From: Suzanne Taylor
Sent: 05 July 2023 13:44
To: Claire Britton
Cc: Caroline Ford
Subject: Update/response re: Hawkwell Farm, NW Bicester for Hallam Land ref: 21/04275/OUT

Policy Bicester 1

Bicester, NW
Development Framework Plan

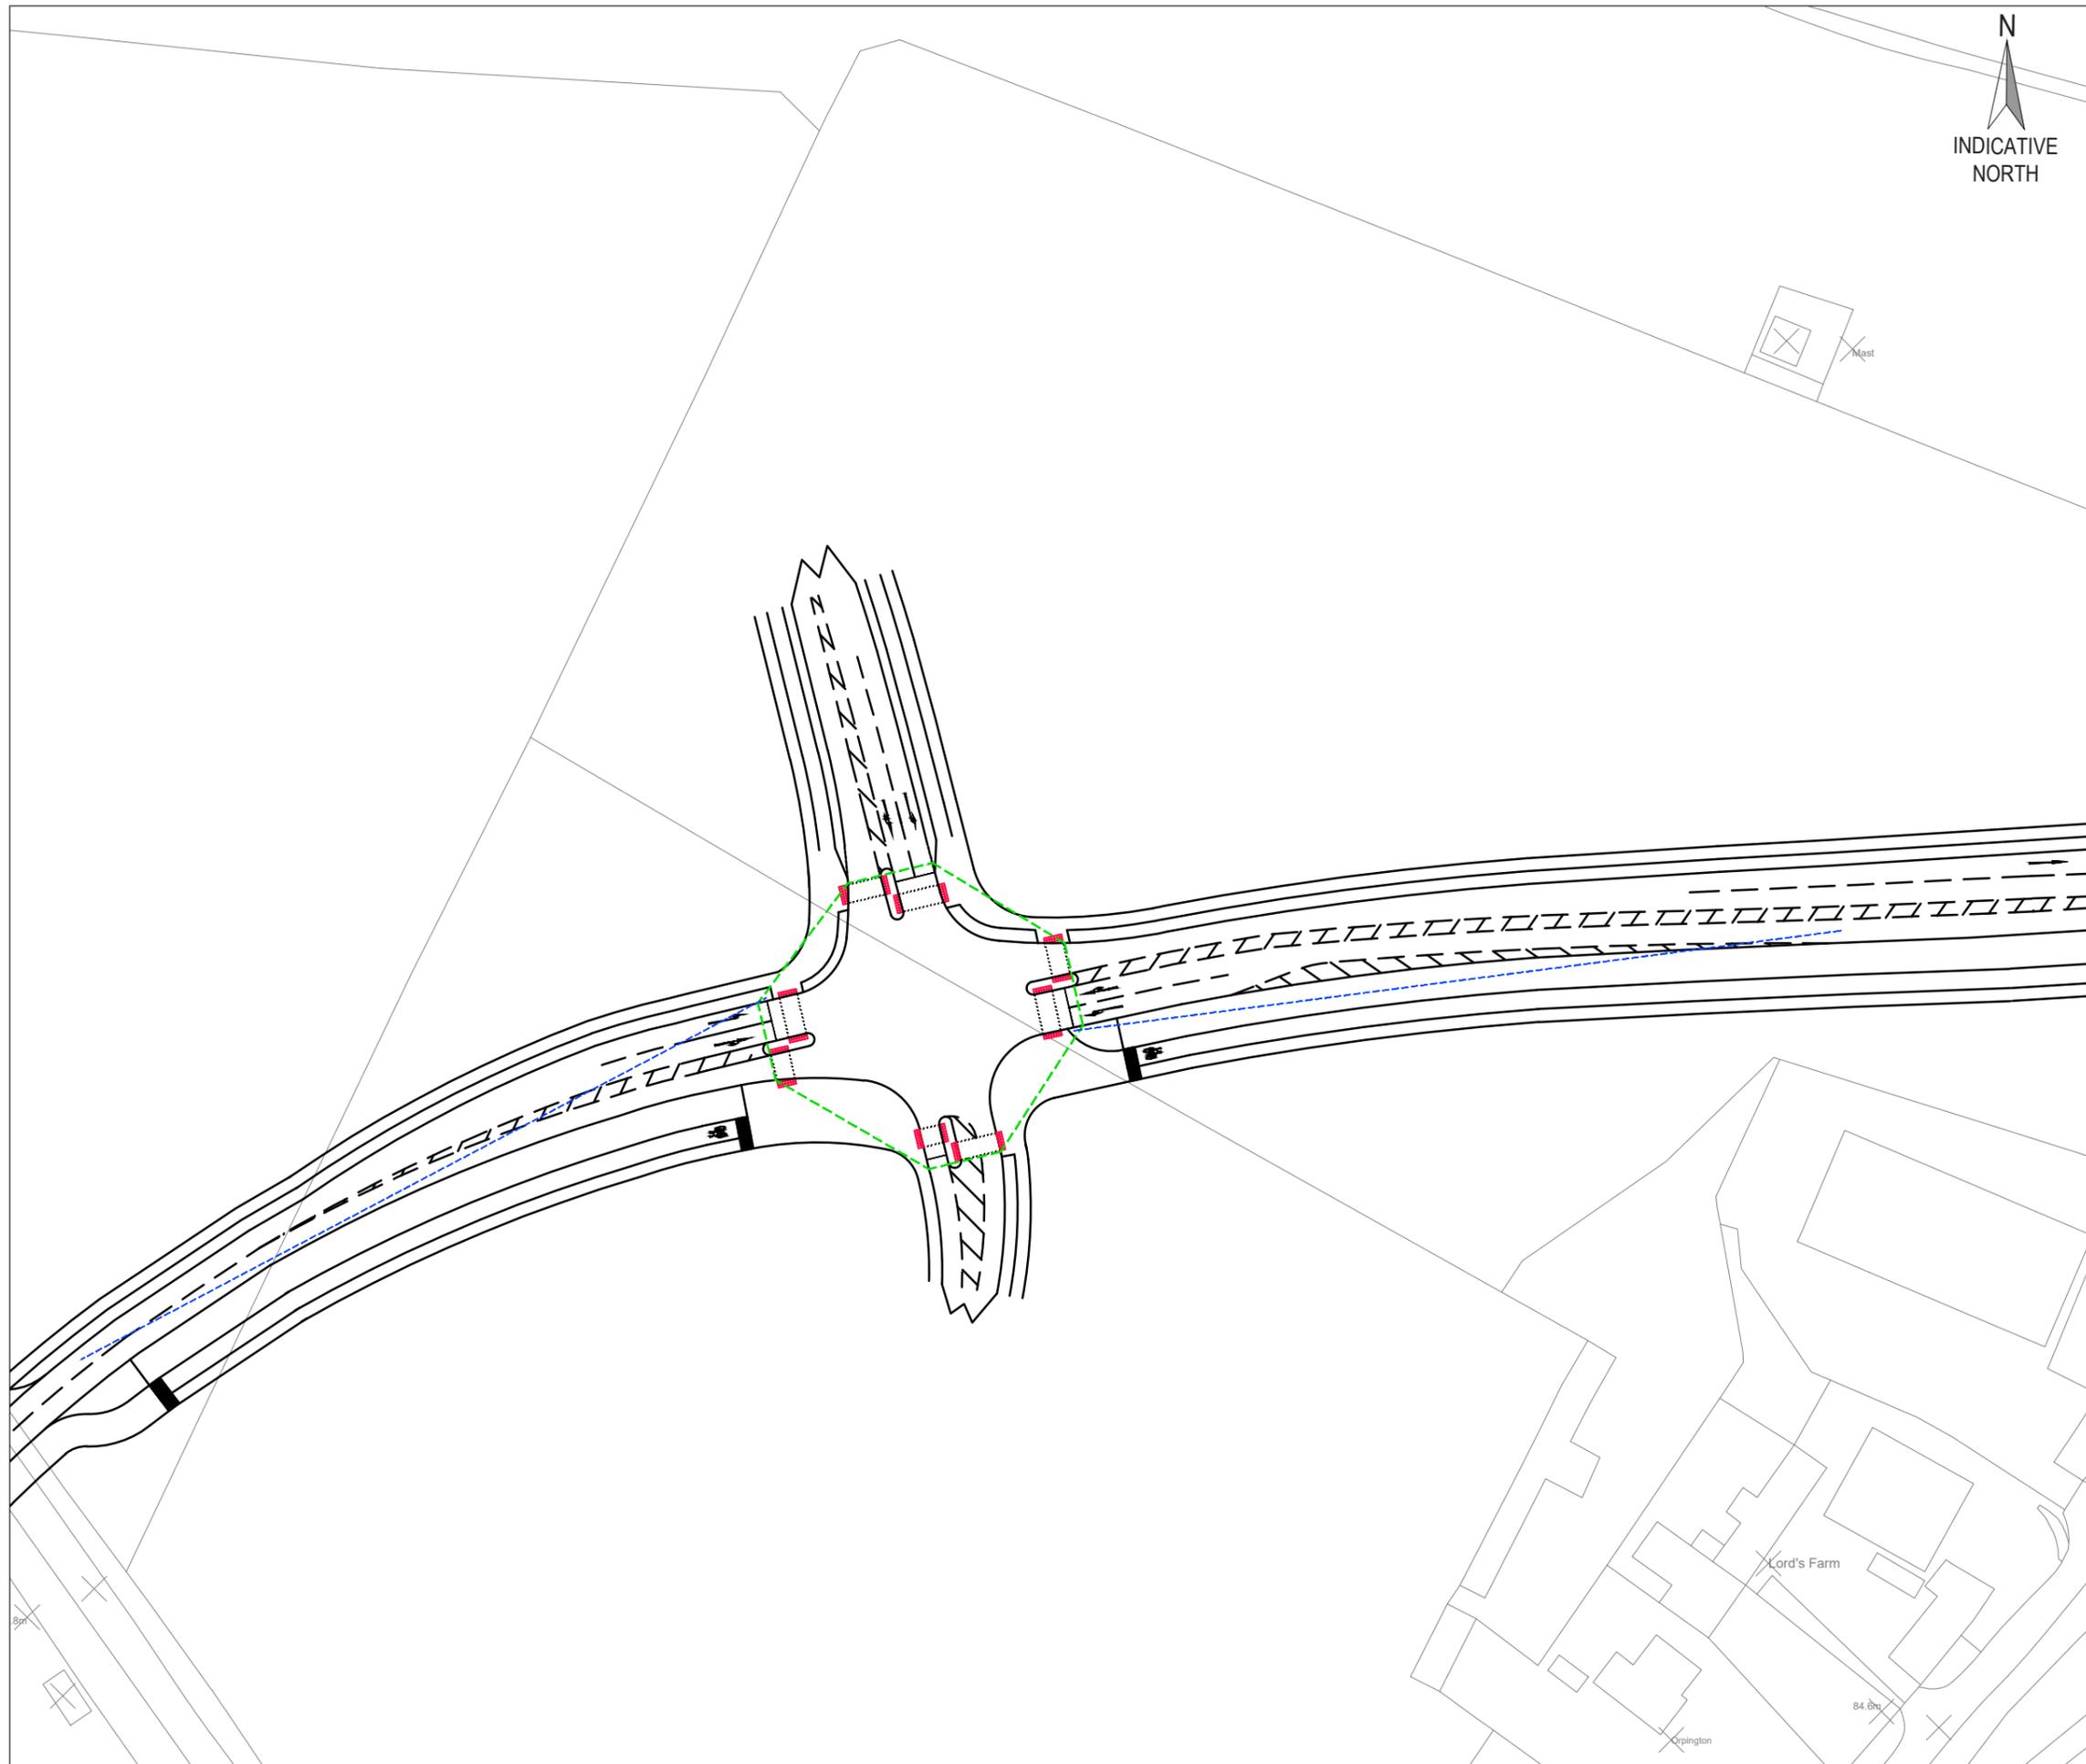
Consider that there are currently an inadequate number of play areas shown on the DFP. The Developer Contribution SPD would require over 6ha of space for play areas based upon the population generated by this number of dwellings (as set out in the draft HoTs). This would equate to a minimum of 4 NEAPs (8000sqm) and 6 combined LEAP/LAPS (4000sqm) OR 3 NEAPs, 5 Combined LEAP/LAPS and 4 LEAPs (3600sqm). Therefore, 1 NEAP and 4 LEAPs would not be adequate. A NEAP and a LEAP/LAP play area should be provided to the north of the site adjacent to largest area of GI and the Community Park and a NEAP should also be provided to the west of the Bucknell Road. A NEAP and/or LEAP/LAP should be located close to the primary school sites.

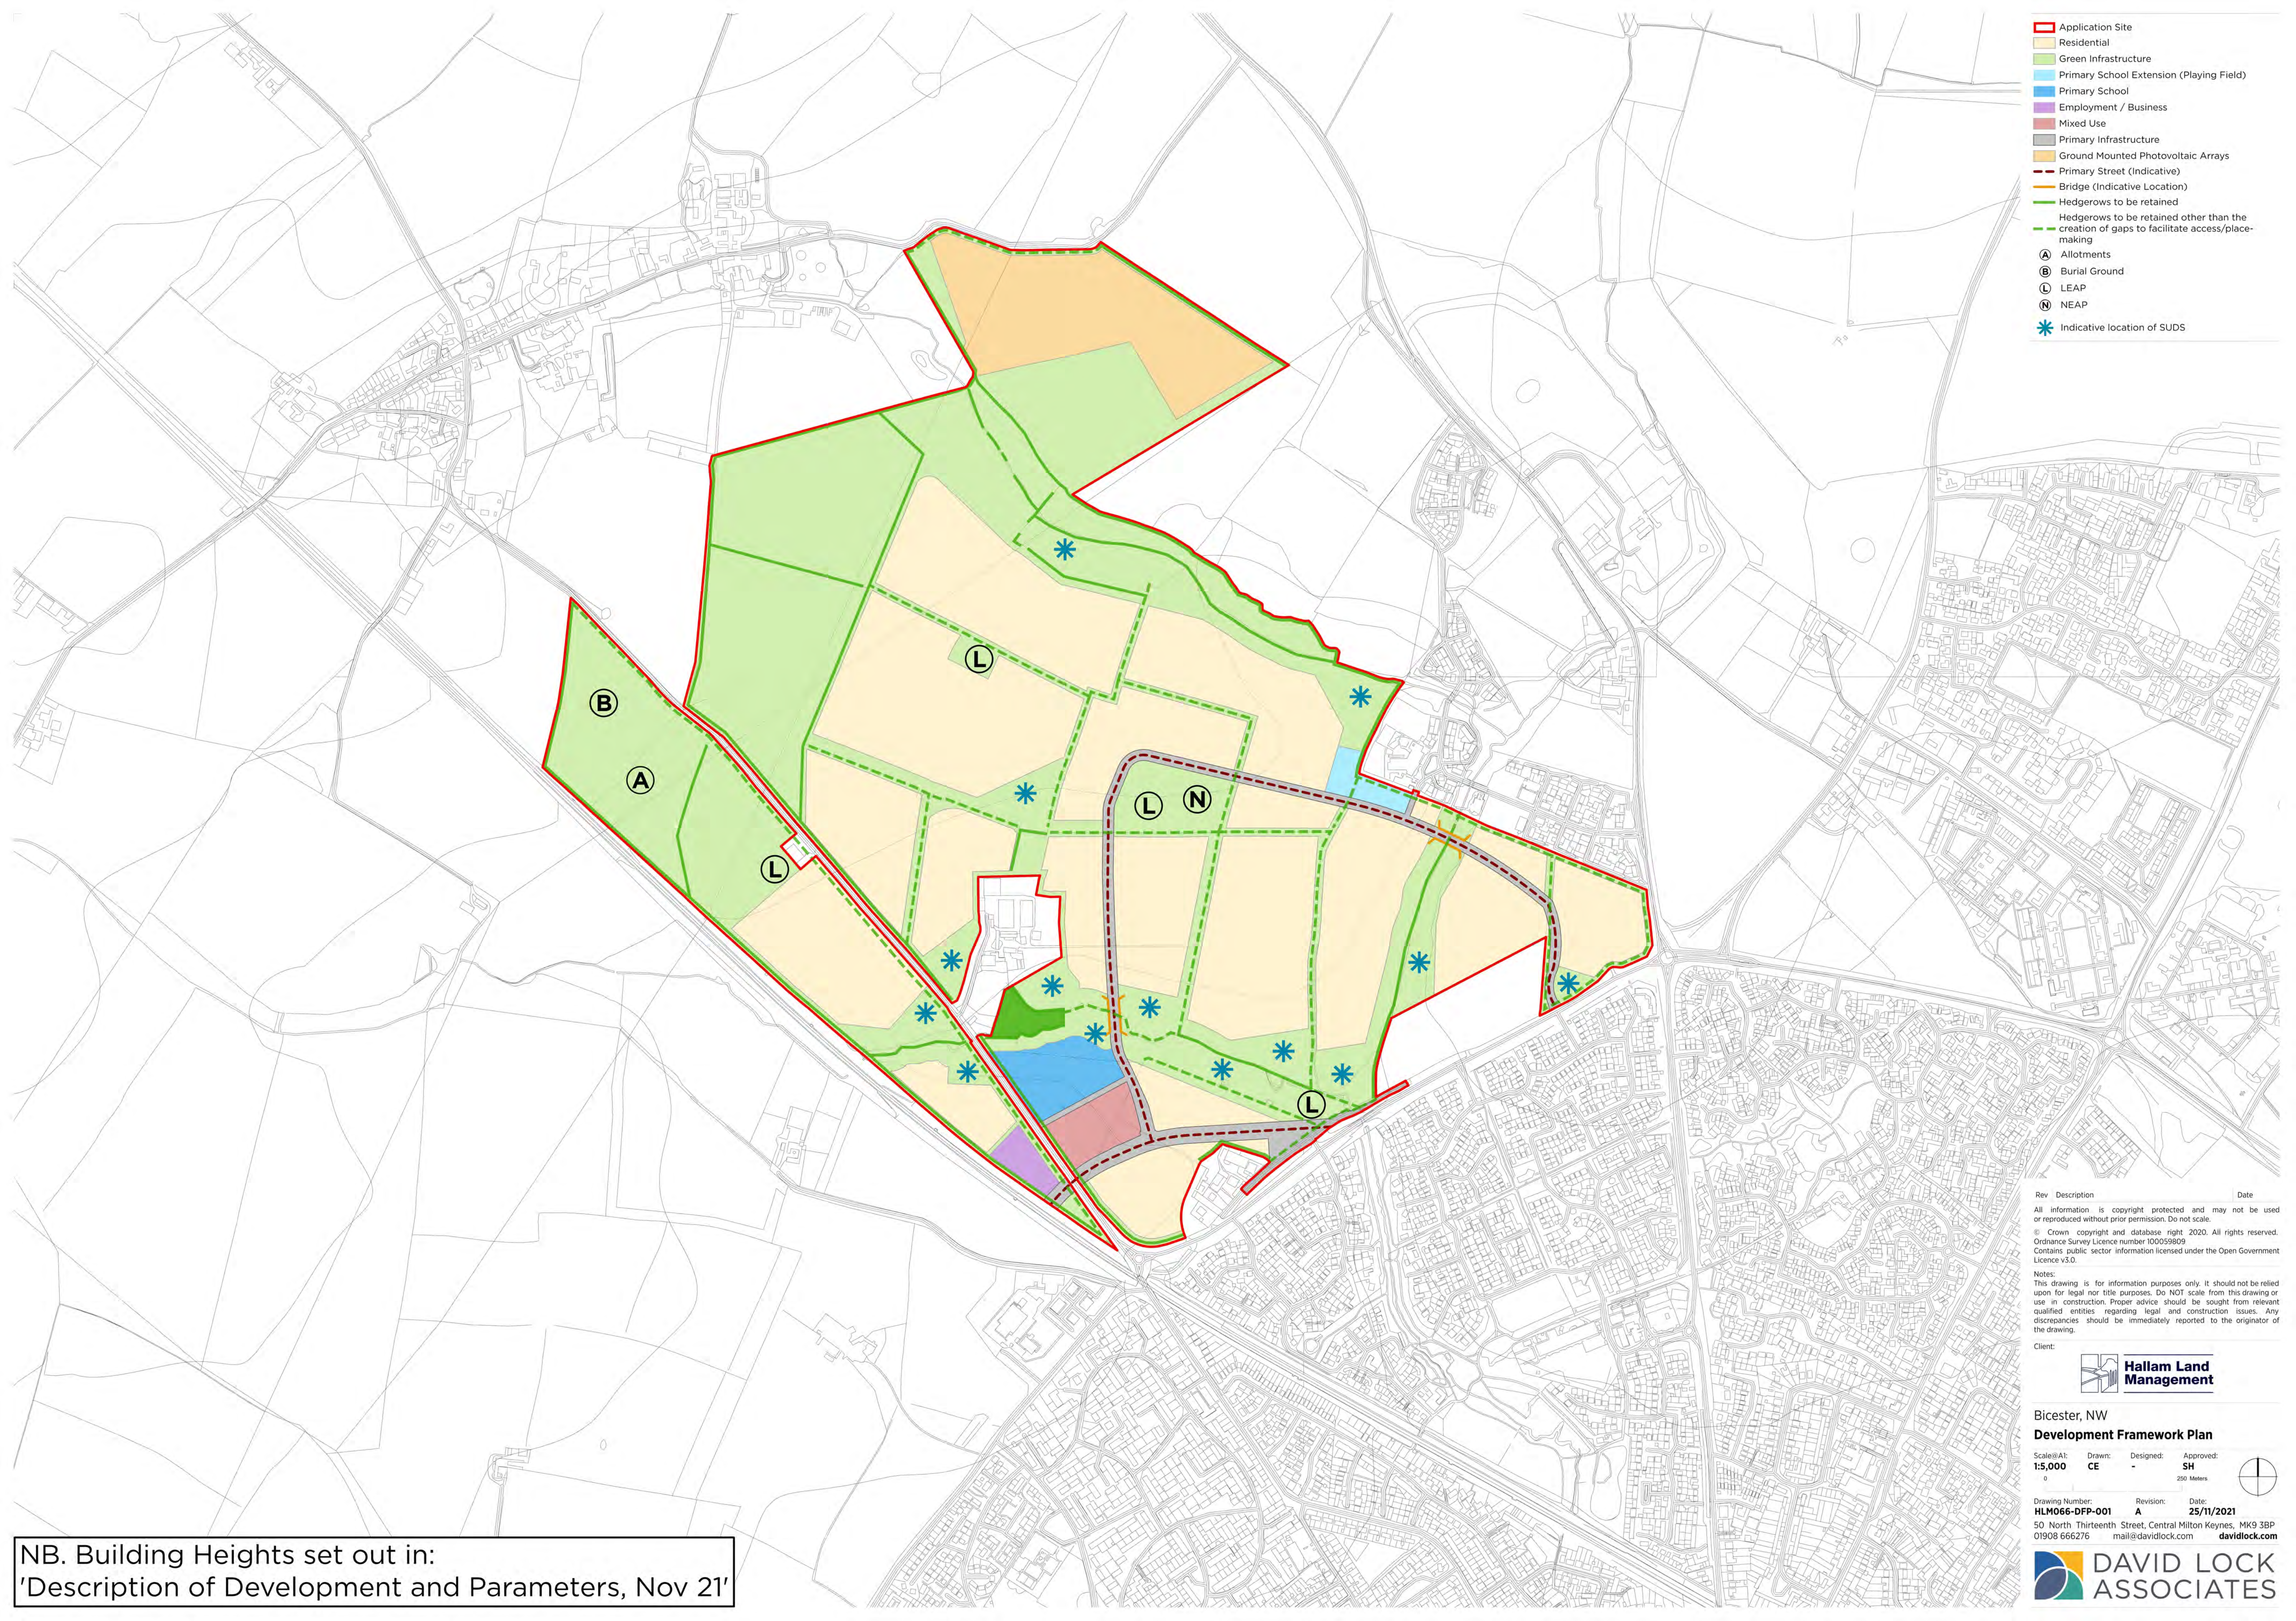
village. Katherine's email requested clarity in the proposals to show that 20m buffers would be provided for retained/reinforced hedges and 60m corridor for watercourses but this has not been explicitly addressed in your response. This should be provided please.

Need to ensure that any development adjacent to the existing Hawkwell Farm and Lords Farm allows for the creation of enclosed perimeter blocks with new development backing on to their existing rear boundary enclosures. The small triangular area of land to the north east of Lords Farm for example looks tight and so it would be appropriate for more detail to be provided to demonstrate that this would be a suitable development parcel. It appears that green landscape buffers are indicated on the Development Framework adjacent to these boundaries so this would either need to be within private rear gardens or not publicly accessible. This could be problematic because it would be difficult to ensure that the buffer is retained and properly maintained if it is in the control of private occupiers rather than within the managed, public open spaces/GI. Would welcome your views on how this could be dealt with.
